# **AXIS J9**

Phase 3 Technical Note Addendum

*(Application No. 21/03177/F)*

Phase 3 External Works & Levels 1:1000

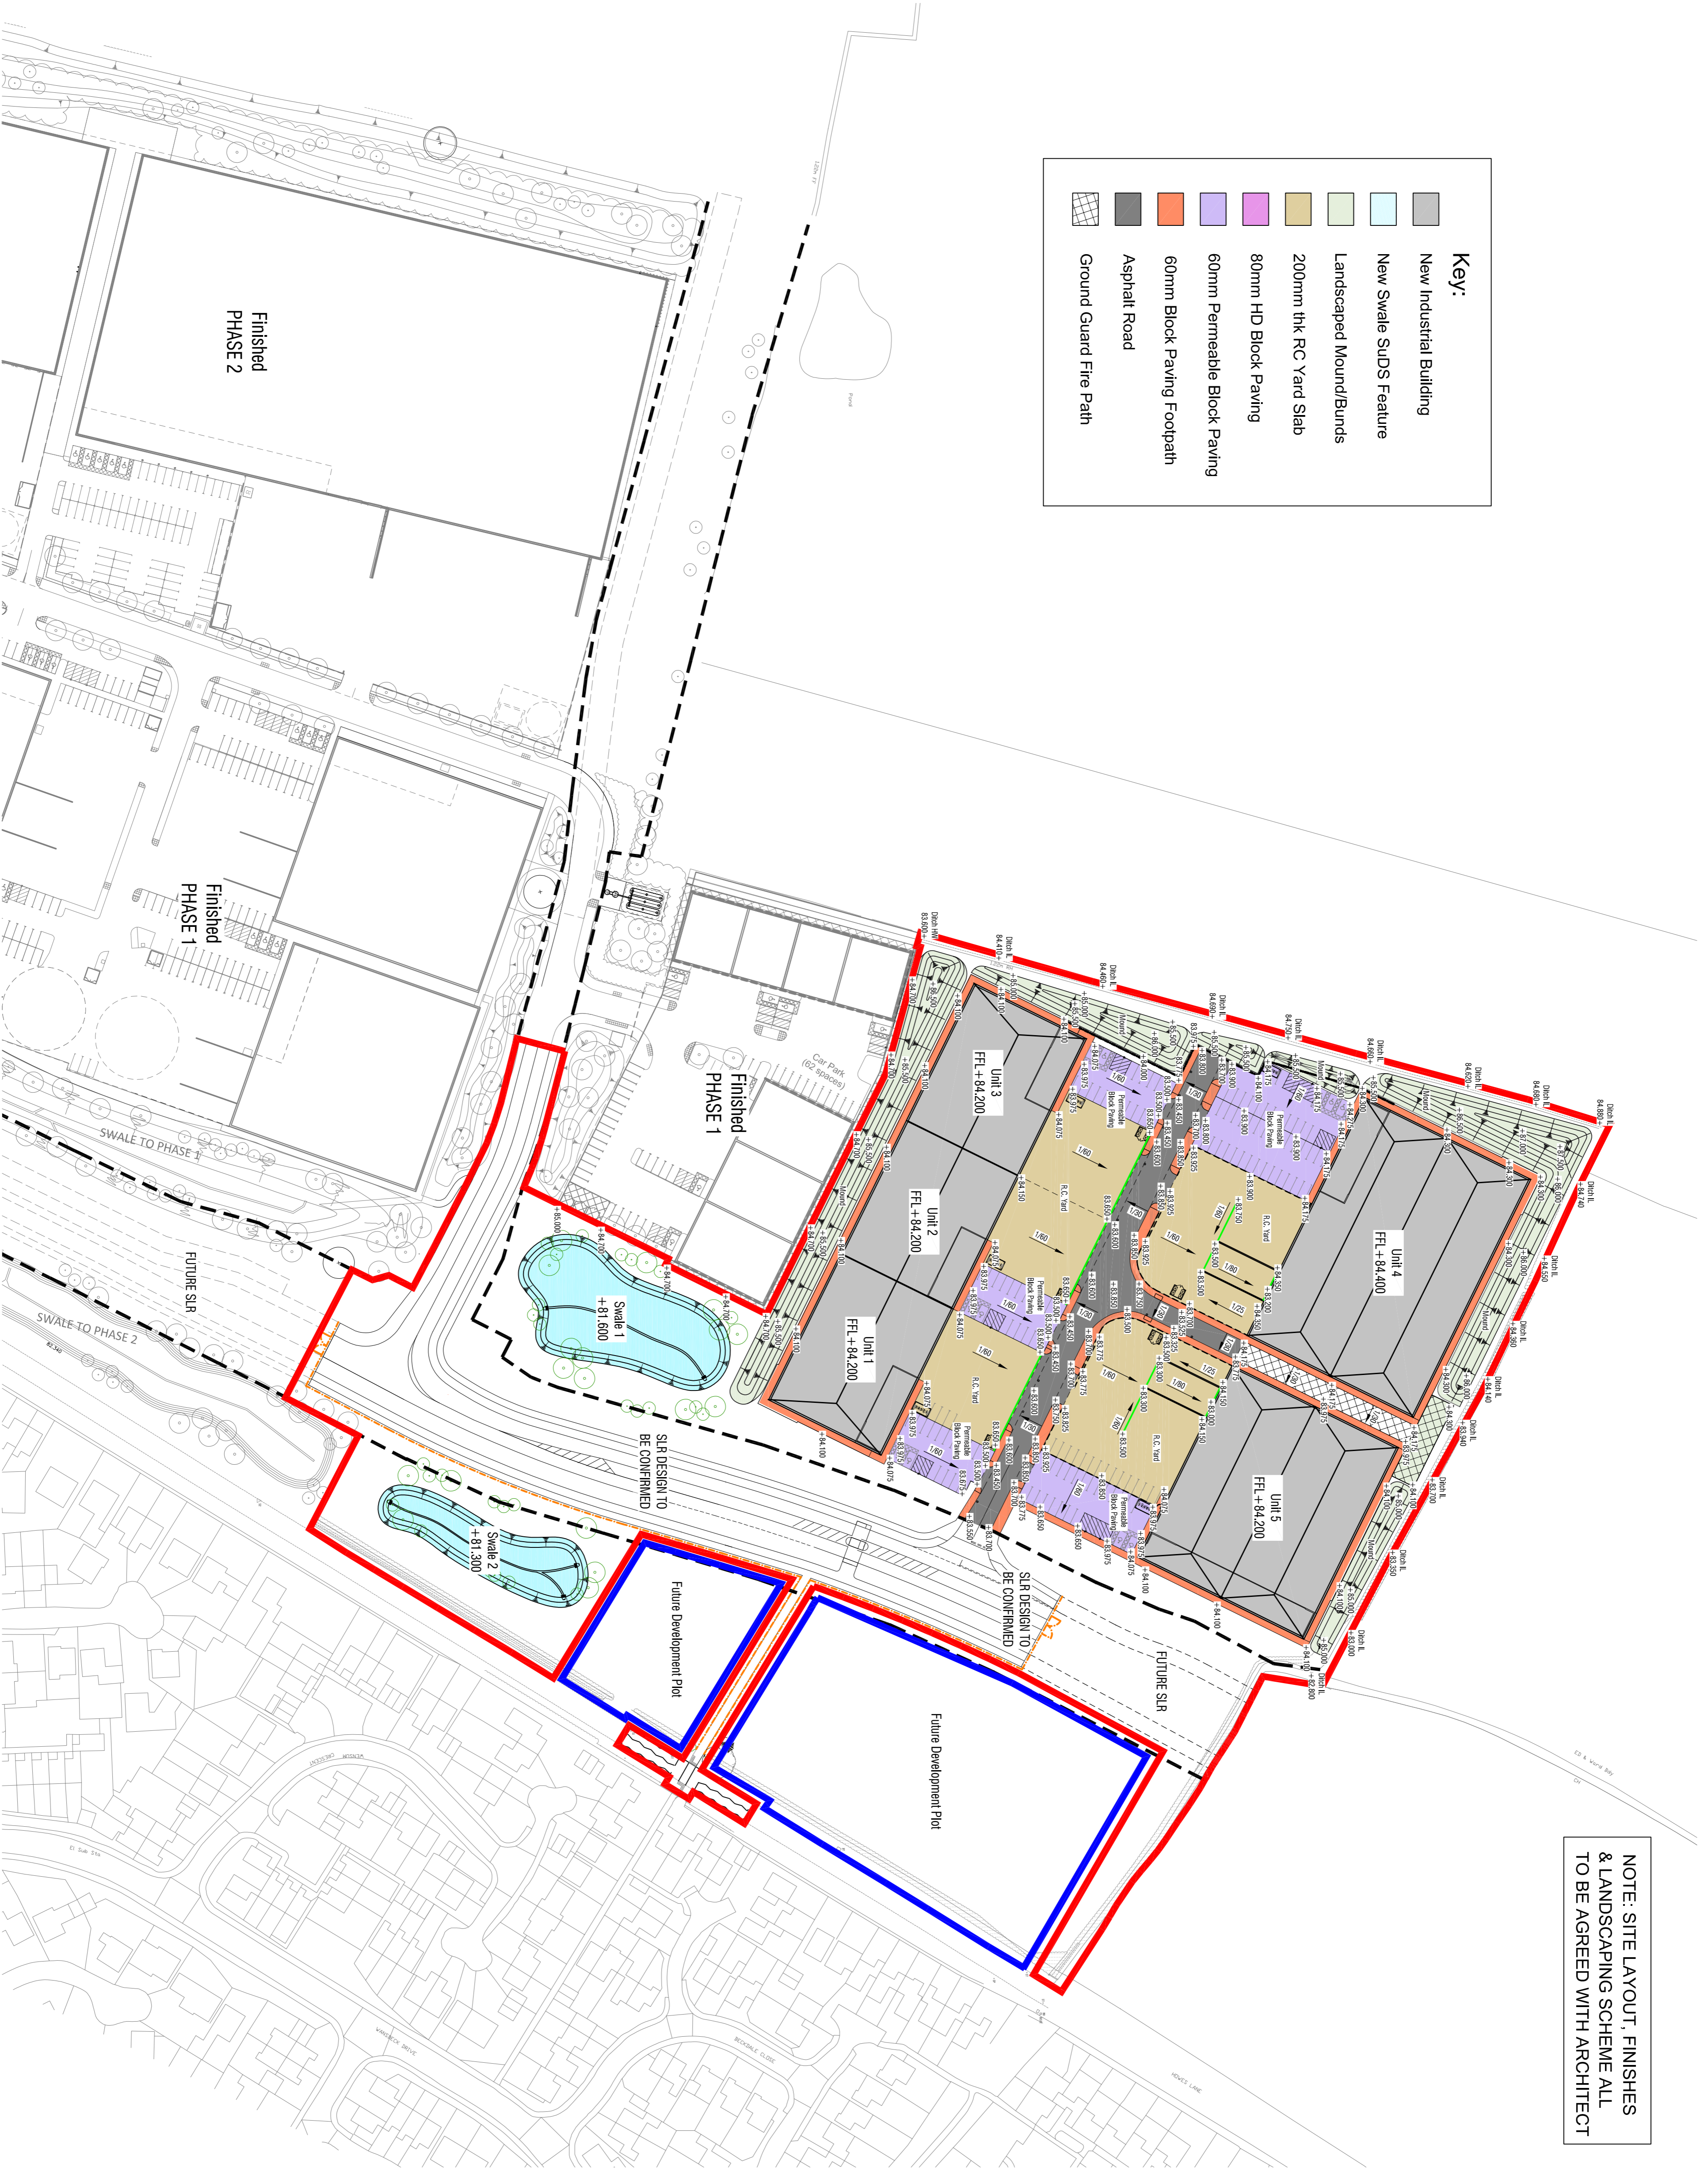
Surface water catchment plan does not show the extent of the areas clearly. Please make use of different colours and hatch the areas solid, clearly stating the area and also the area with urban creep.

Basin cover levels are not provided on the plan drawings, please provide cover levels of storage structures and the volumes.

The future SL area is not covered in the phase 3 drainage strategy however its shown within the phase 3 development. Clarification on the drainage strategy is required.

Plan drawing shows headwall discharging to an green hatched area. This has not been denoted on the key. The outfall location should be clearly shown on the drawing and where it leads to exactly.

Parking spaces opposite units 6-8,9-10 and 11 does not have permeable paving. Clarification required on how the surface water in this area will be treated.

Permeable paving is proposed however this has not been keyed up on the drainage strategy drawing. Also provide storage volumes and invert level of the sub base on the drainage plans. All SuDs features and drainage infrastructure should be keyed up correctly on drainage plans.
